Application number: 2024/90561	
What is the application for?:	Erection of side and rear extensions with associated alterations
Address of the site or building:	82, Jenkyn Lane, Shepley, Huddersfield, HD8 8AW
Postcode:	HD8 8AW

Type of comment: An objection	
Do you wish your comments to be published on the website anonymously?	Yes

PROJECT TITLE Proposed Side and rear extension @ 82 Jenkyn Lane Shepley	CLIENT Ian Spedding 82 Jenkyn Lane, Shepley
DRAWN BY Ian Spedding	DRAWING NO I.S 002
DATE February 2024	SCALE Proposed plans 1:100 @ A3

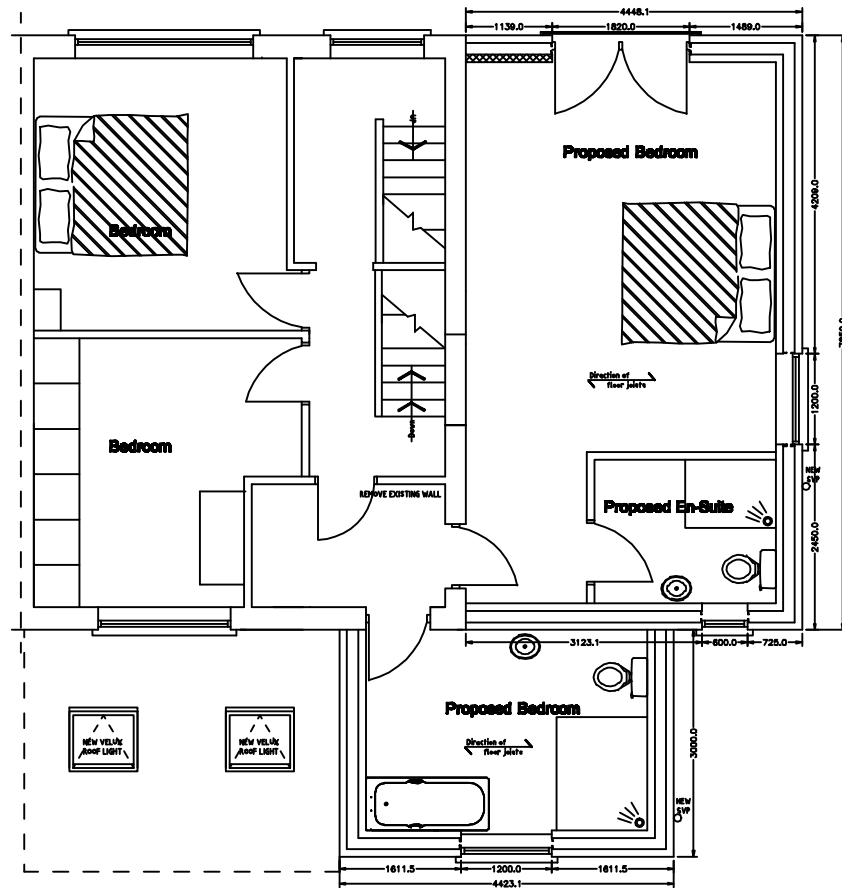
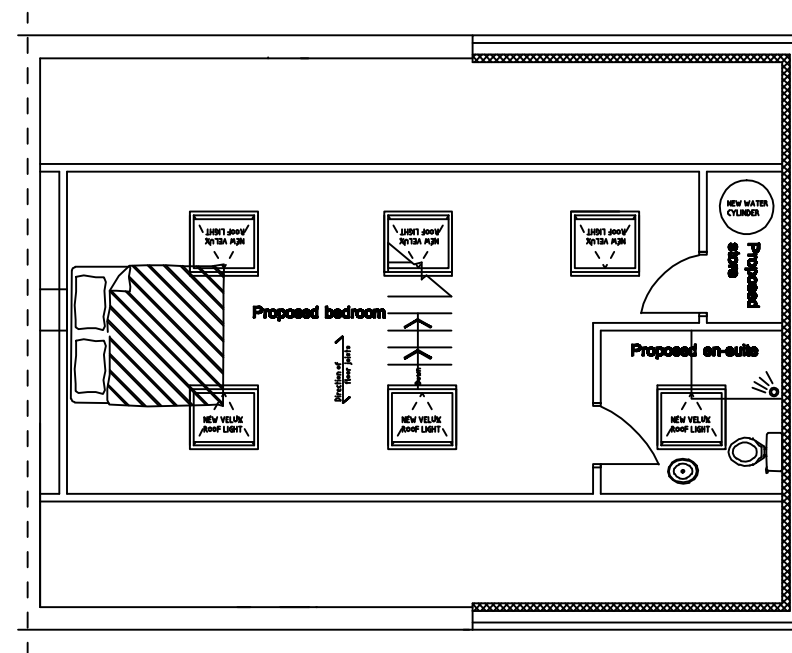
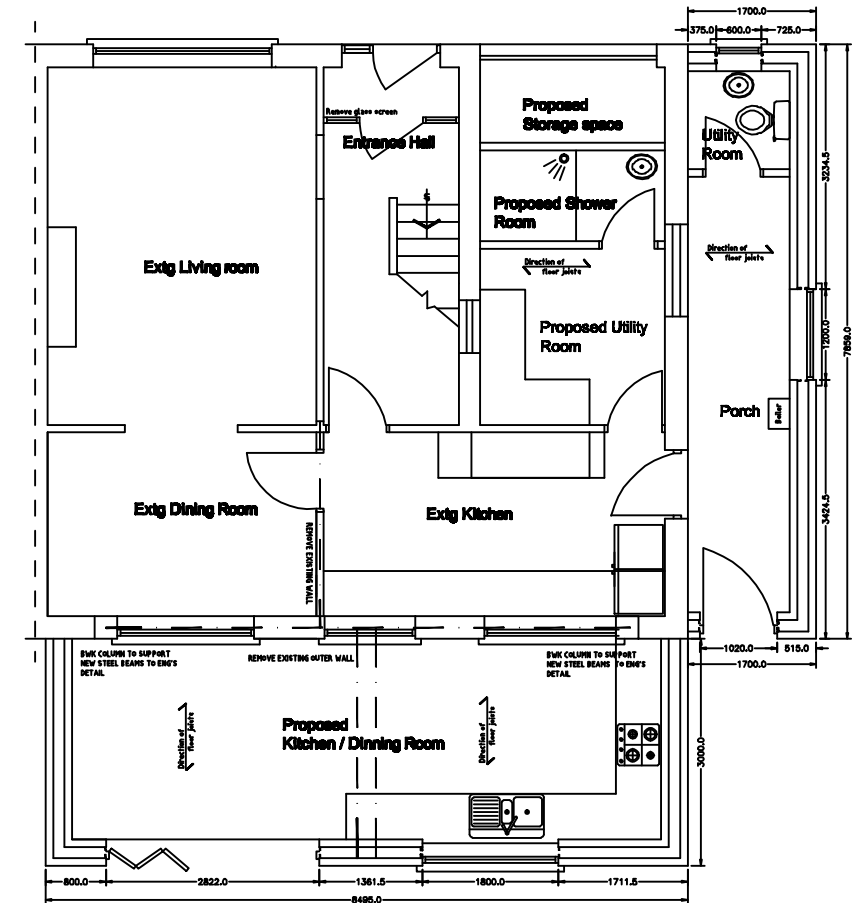
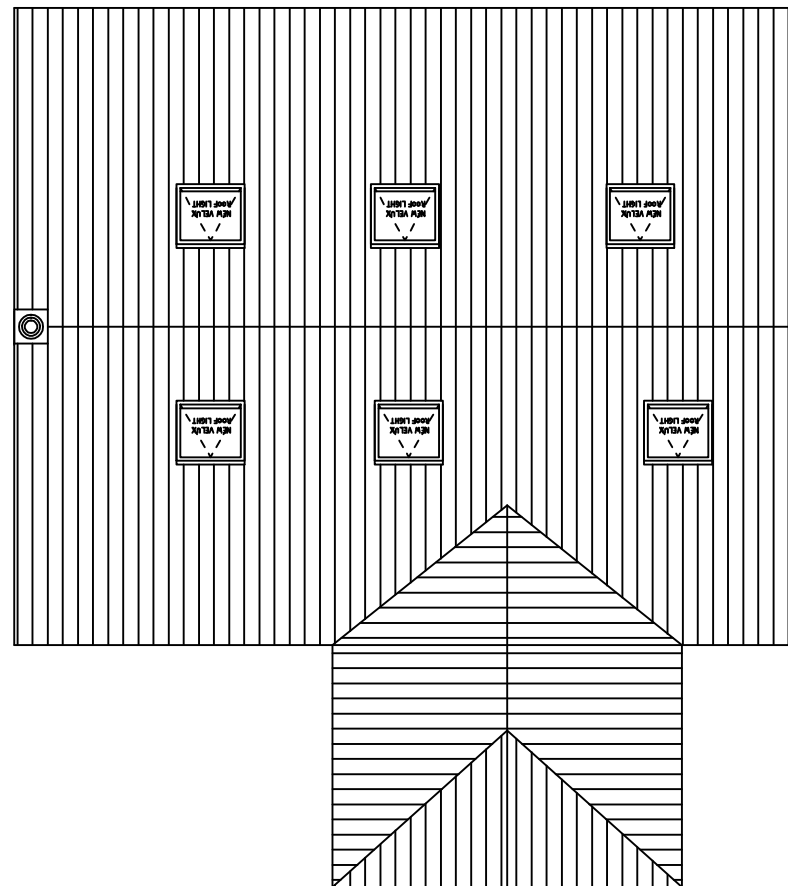
- are out of proportion with the existing house adding 50% to the ground floor area and doubling the first floor, as well as creating additional large living space in the existing loft. So the extensions are not "subservient to the original building" or "in keeping ... in terms of scale" (Kirklees Local Plan Policy LP24). This gives the potential for future over-accupation of the site compared with other houses in the area, with a risk of excess noise and disturbance.

- would have a bedroom window facing bedroom windows of neighbouring houses at a distance of only about 16m, less than Kirklees' recommended minimum of 21m. (Supplementary Planning Document 4.10)

PROPOSED SITE PLAN 1:500 @A4

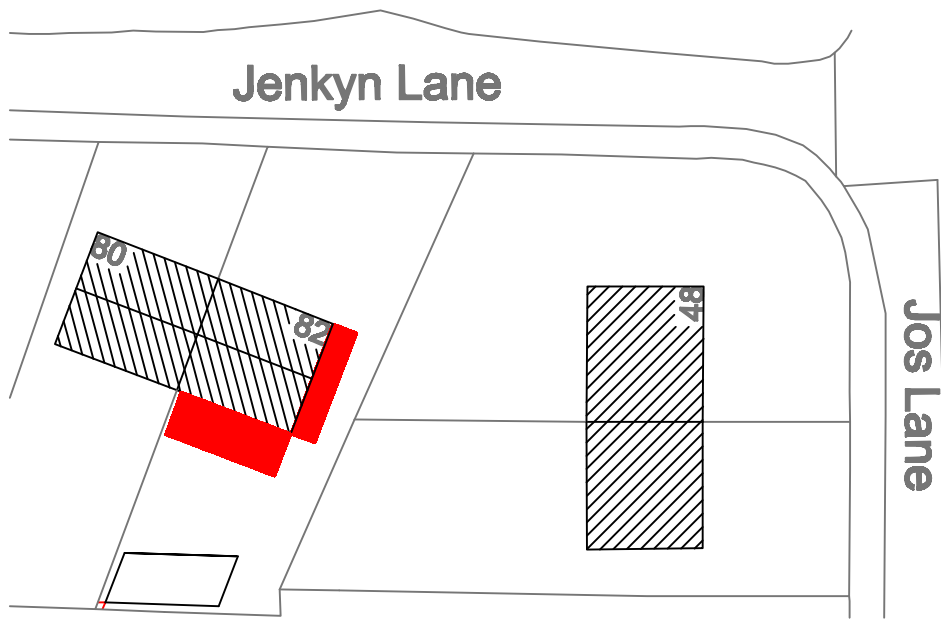
- would reduce the back garden space of the property, where a large summer house has also recently been built, and there is also an older existing shed. Taken together, these considerably reduce the "useable area of private outdoor space for the property" (Extensions & Alterations Supplementary Planning Document 4.21)

<p>PROJECT TITLE Proposed Side and rear extension @ 82 Jenkyn Lane Shepley</p>	<p>CLIENT Ian Spedding 82 Jenkyn Lane, Shepley</p>
<p>DRAWN BY Ian Spedding</p>	<p>DRAWING NO I.S 004</p>
<p>DATE February 2024</p>	<p>SCALE Proposed Elevations 1:100 @ A3</p>

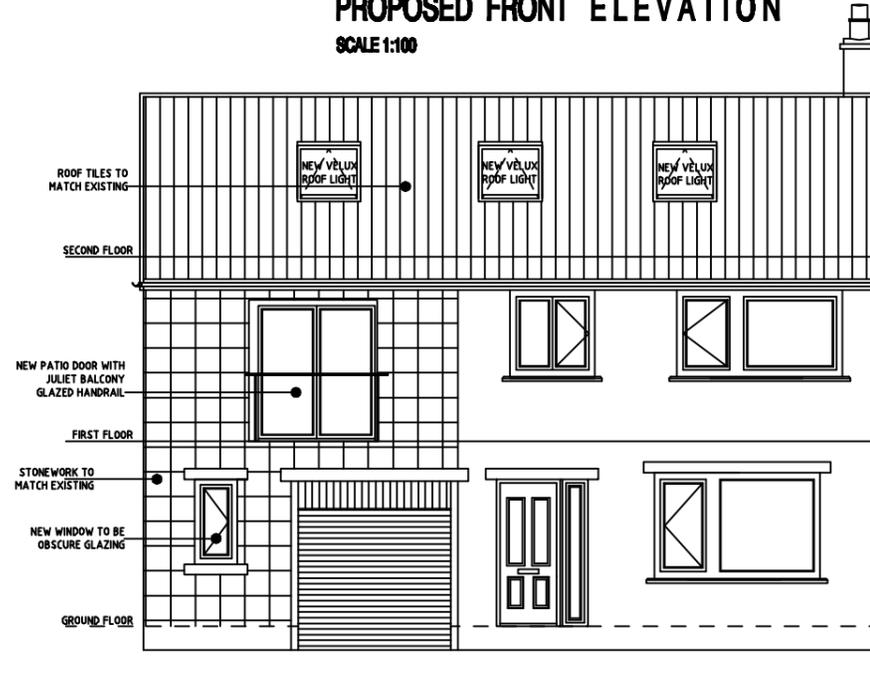
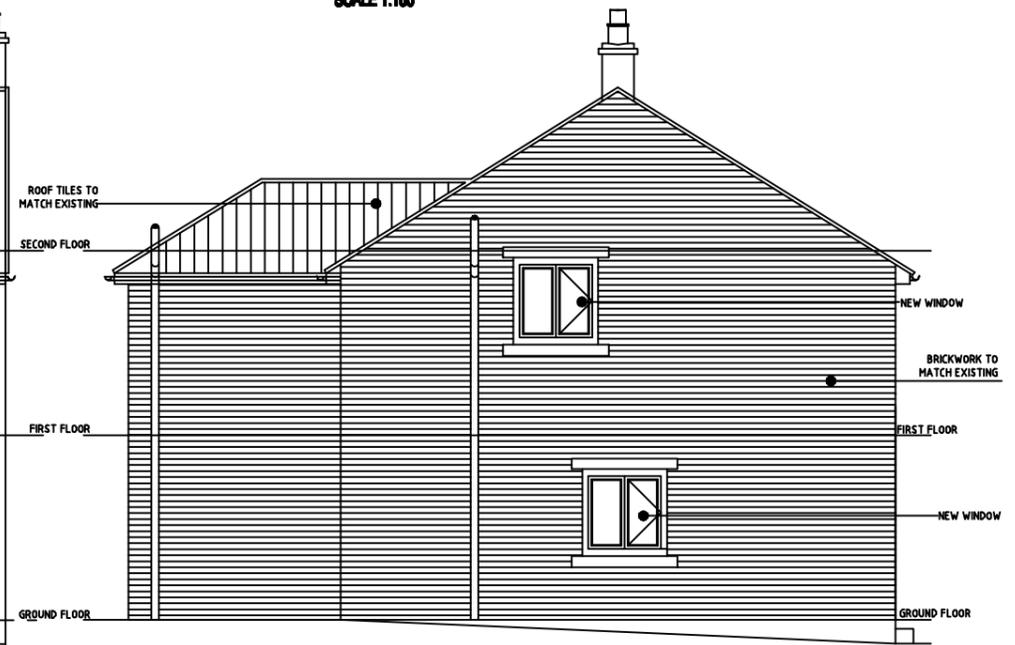
- are out of character with the area and extensions to other local houses, particularly the 2 storey extension at the side, going above and beyond the existing garage, in line with the front of the house, and with a gable replacing the pitched roof line. This is not "in keeping with the existing buildings in terms of ... details" (Policy LP24) Whilst other houses in the area have extended over the garage, they have retained the pitched roof or used flat roofs; extensions beyond the side of the garage have been restricted to the ground floor, and are generally set back from the house front.

- include a 2 storey, 3m extension across part of the back of the house, with a pitched and hipped roof at right angles to the existing roof line. Again, this is out of keeping with other local houses which have made rear extensions, which are generally restricted to the ground floor.

- would have major impact on the residential amenity of 46 & 48 Jos Lane, when extensions should minimise impact on residential amenity (Policy LP24). The gable wall of the side extension combined with the two storey rear extension would dominate and overshadow the back gardens. The new gable is only approximately 1m from the boundary at the nearest point. The domination is exacerbated by the slope, which means that the ground level of 82 Jenkyn Lane is almost 2m higher than the Jos Lane houses: so the wall would appear even higher than two storeys.
